RESPONSE TO SUBMISSIONS – ST GEORGE EMERGENCY DEPARTMENT. SSD 5029

23 October 2012

DRAWING TITLE:
LANDSCAPE PLAN

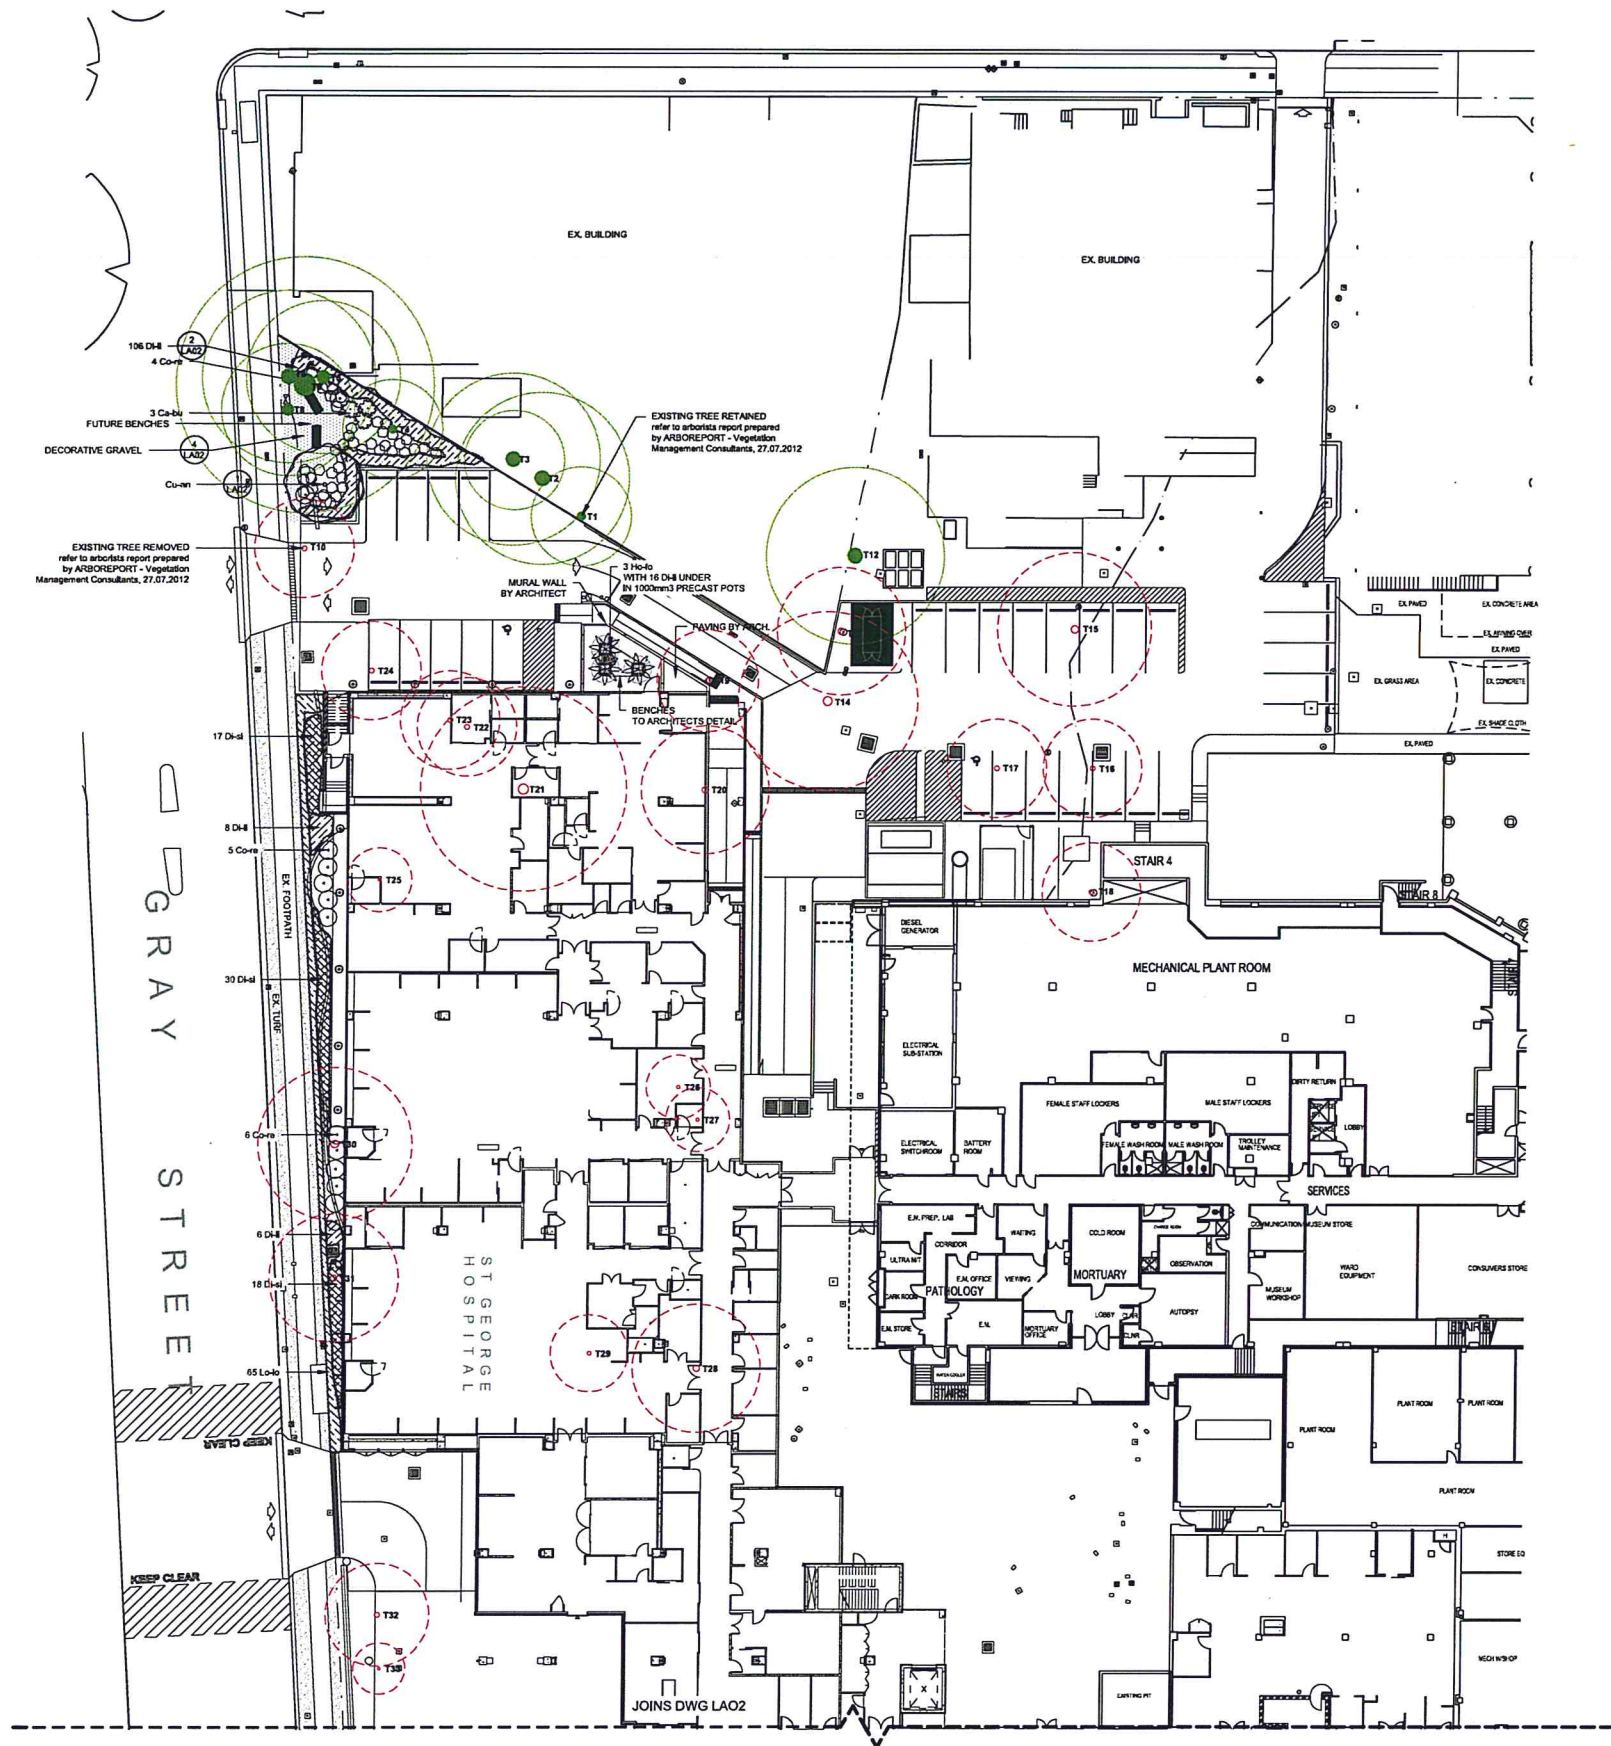
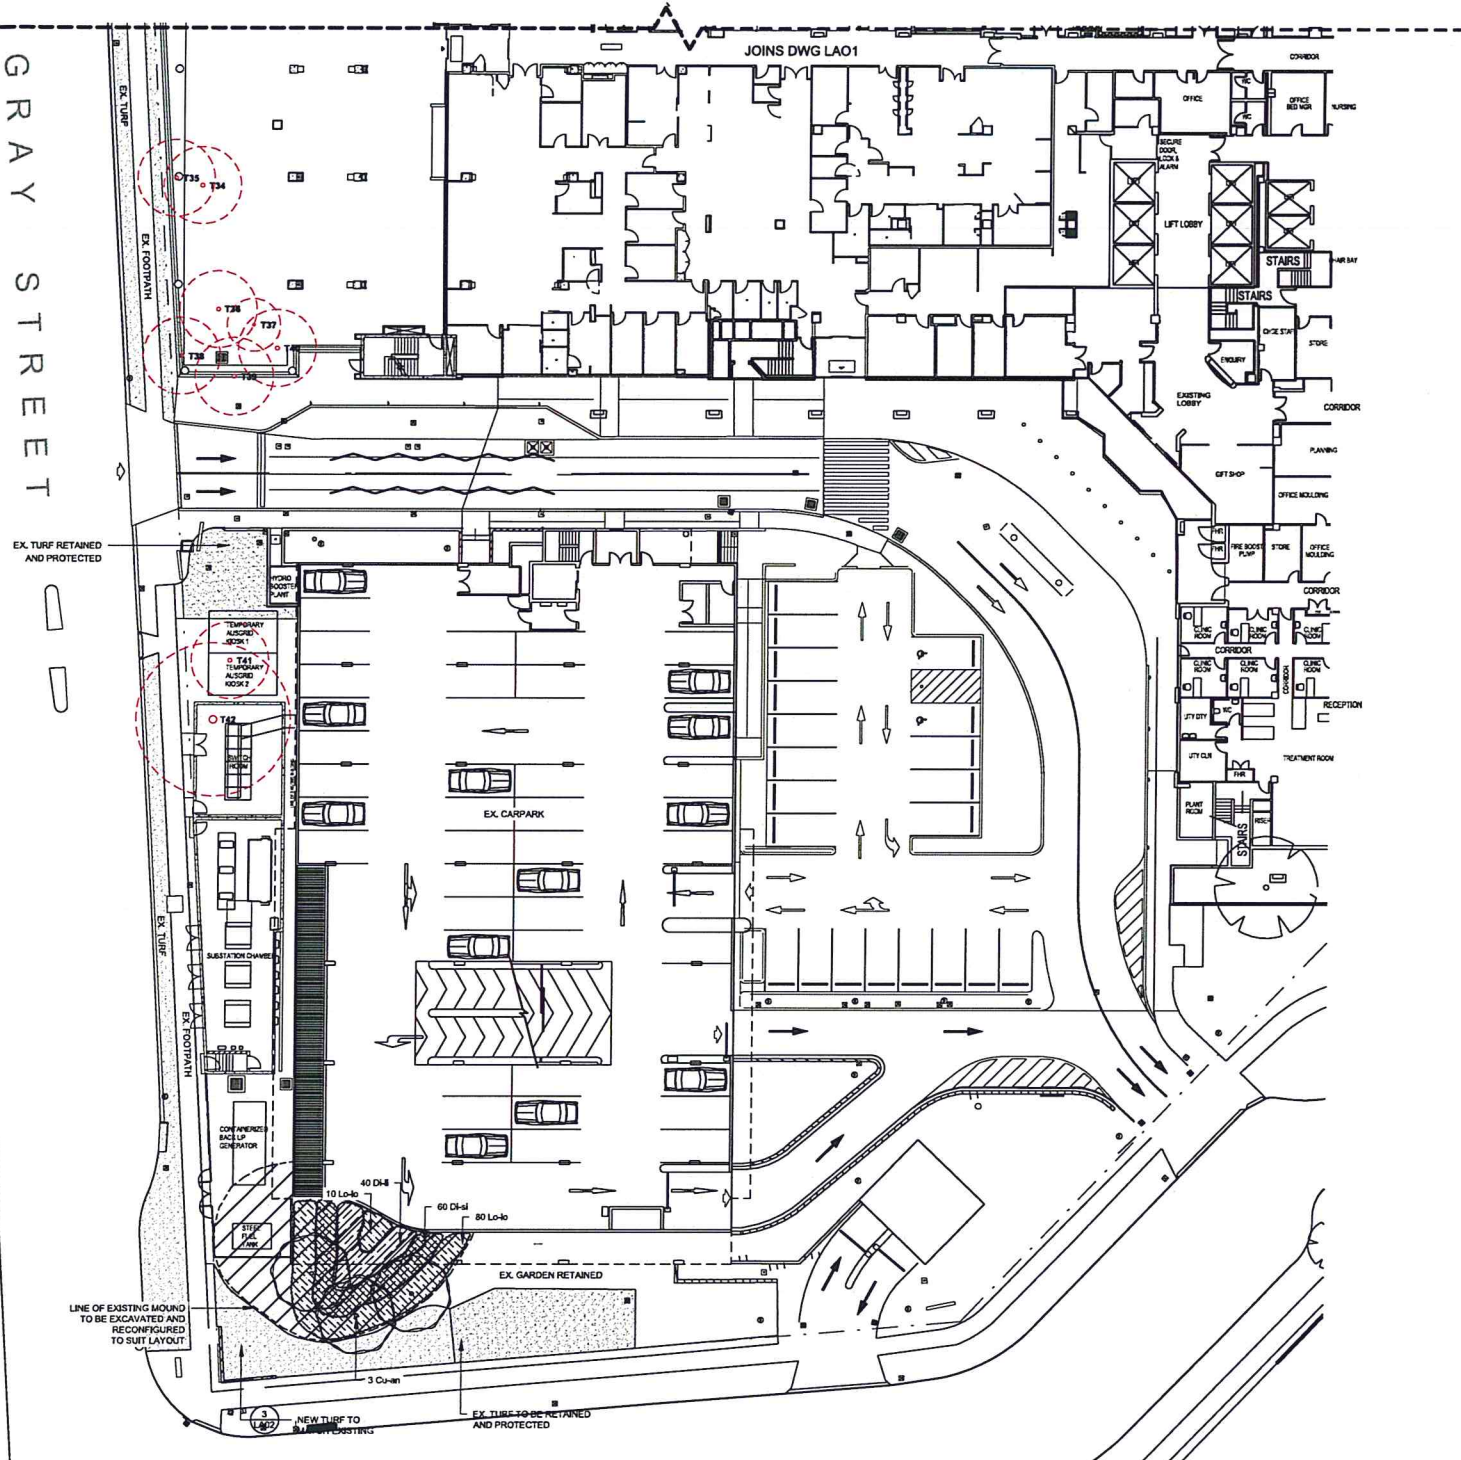
Landscape	
6	Council's Landscape Officer supports the retention of trees 1, 3 and 12, however considers that the proposed development would need to be redesigned to avoid and minimise impacts from the proposed major encroachment. In this regard, Council is recommending the following draft conditions, as outlined below be included, in addition to the conditions already provided to the Department:	Noted
7	Tree Protection • Prior to the commencement of any works on the site the	Accepted subject to the comment above
